Our Ref: BR/80/20/HH
Your Ref:

Town & Country Planning Act 1990 (as amended)
Town & Country Planning (Development Management Procedure) (England) Order 2015
Application for Planning Permission for Works or Extension to a Dwelling

Development Single storey rear extension
Location Brookland Villa Shripney Road Bognor Regis

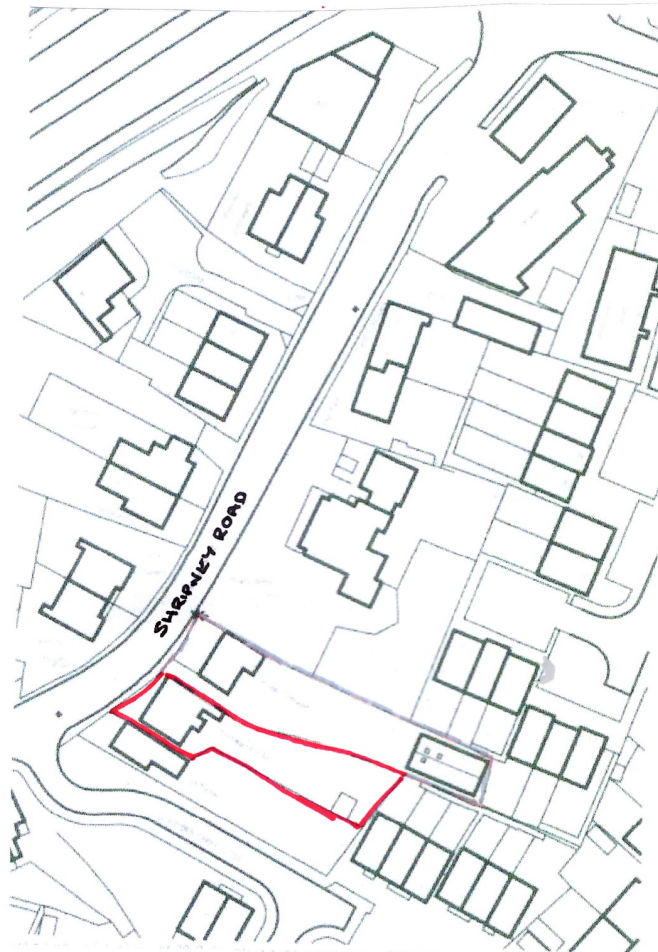
Block Plan: You are required to include dimensions on the block plan from the proposed extension to all site boundaries. Please amend.
